Your Ref: 000014373
Our Ref: R/226/12/ 27-11-2012
Please ask for:
Melissa Osland

Single storey and two storey rear extension including a first floor balcony (revised proposals to R/110/12/)

Dominic House Harsfold Road Rustington

DOMINIC HOUSE, HARSFOLD ROAD, RUSTINGTON
Proposals 02
April 2012

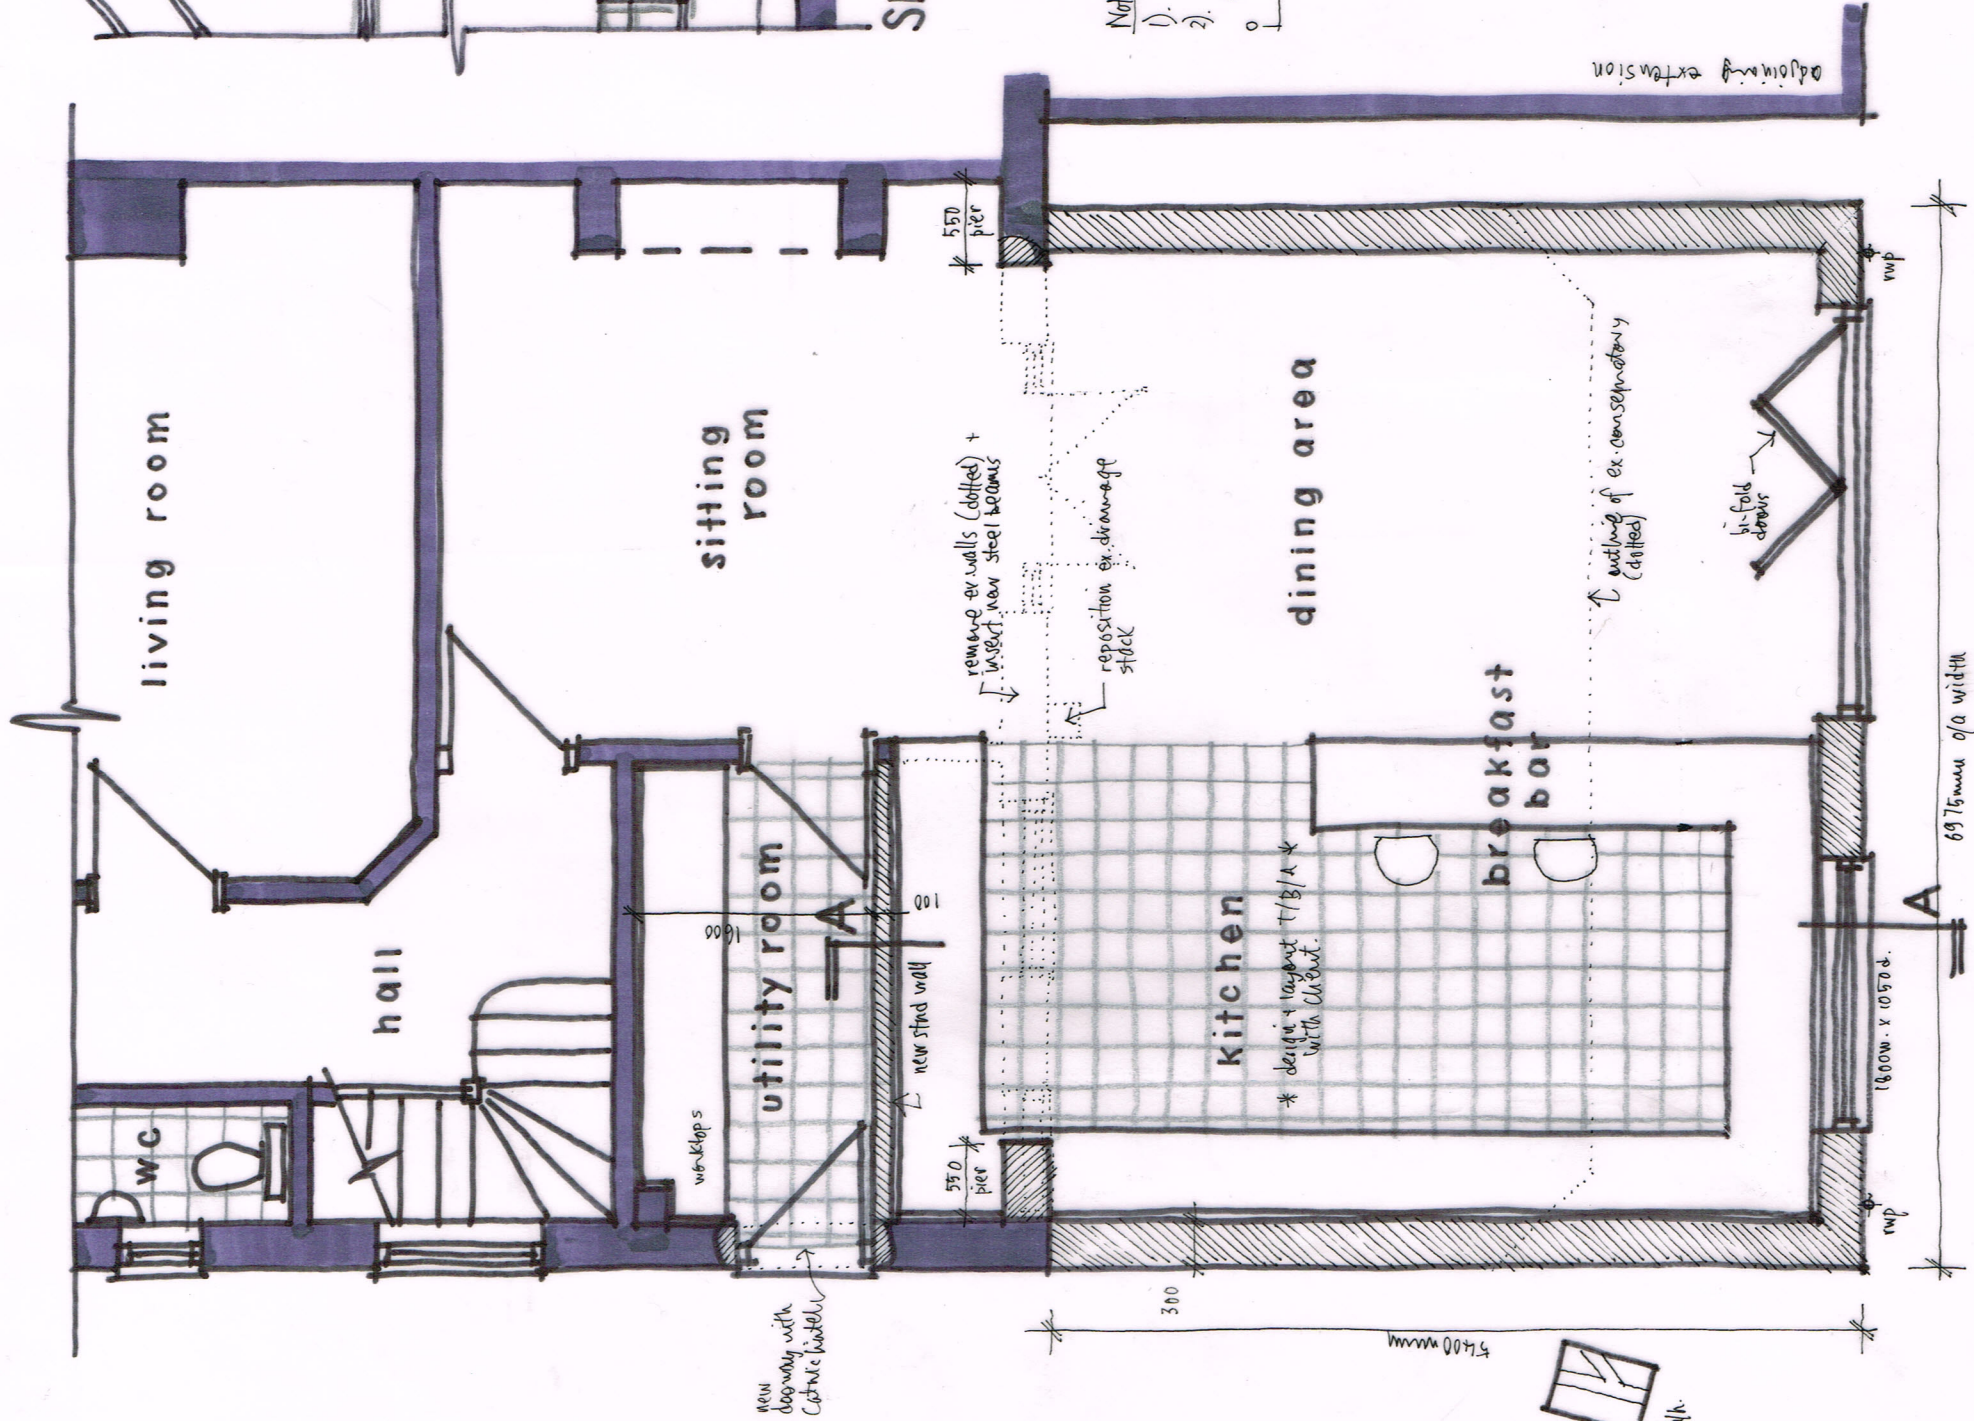
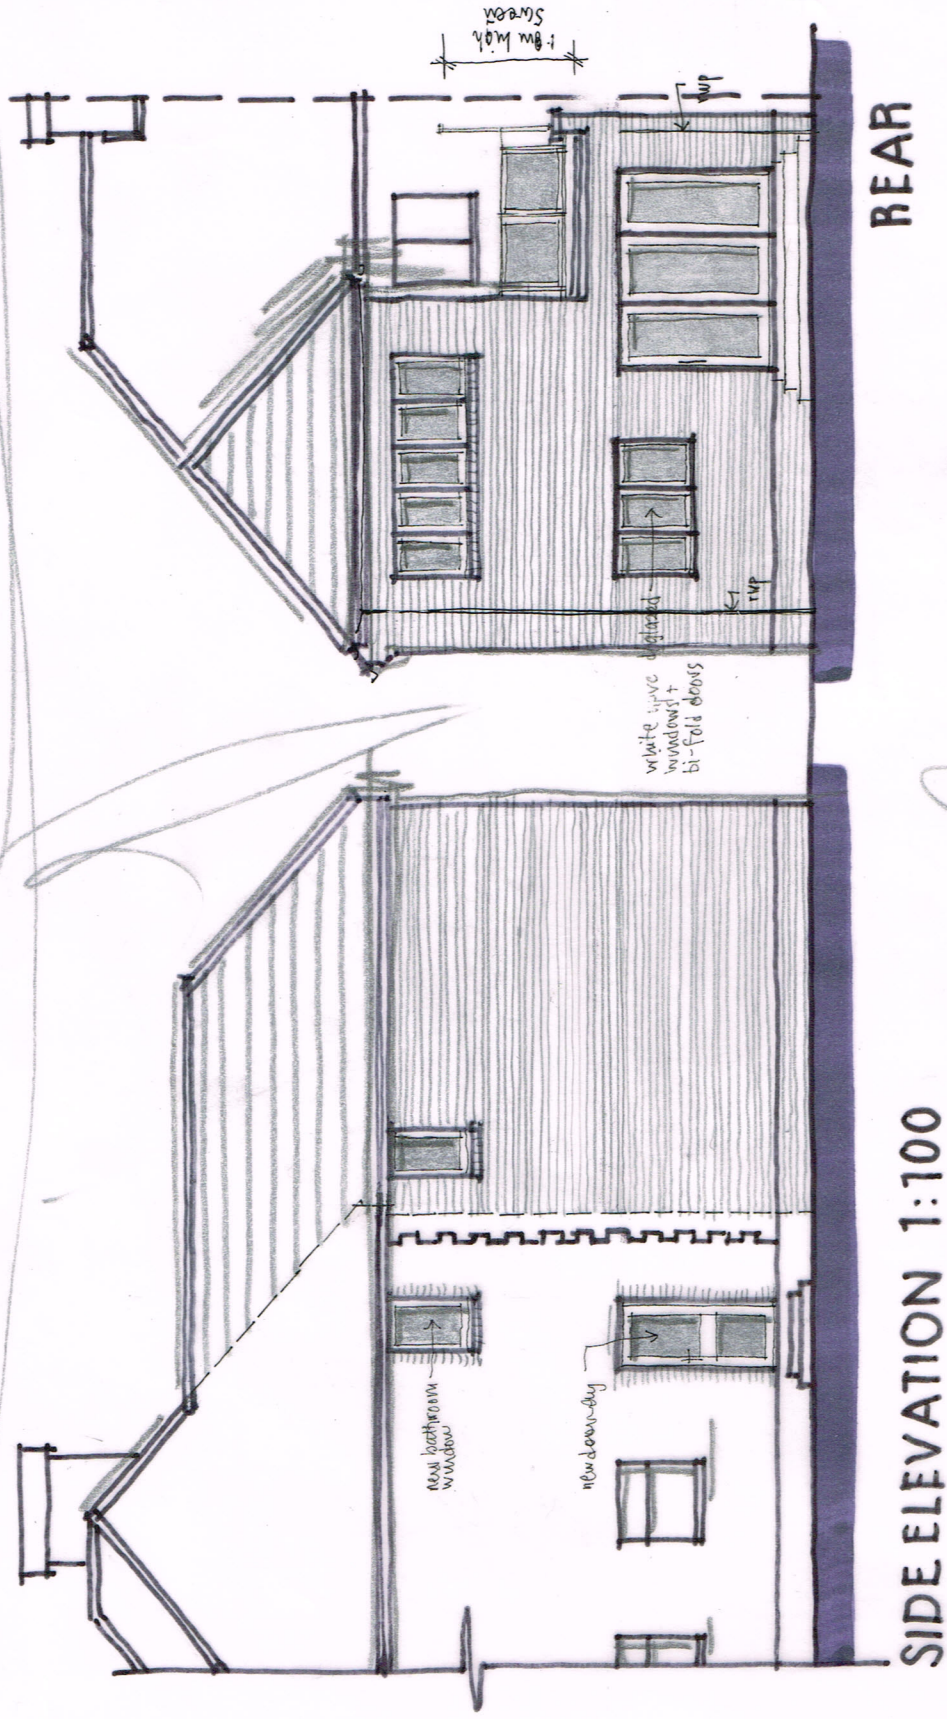
(a) The proposal for a two storey extension, to include a first floor balcony, would result in a loss of privacy for the occupiers of the adjacent property, namely Sea Breezes, by reason of overlooking. This would most certainly adversely affect the quiet enjoyment and amenities of the occupiers of the aforementioned property.
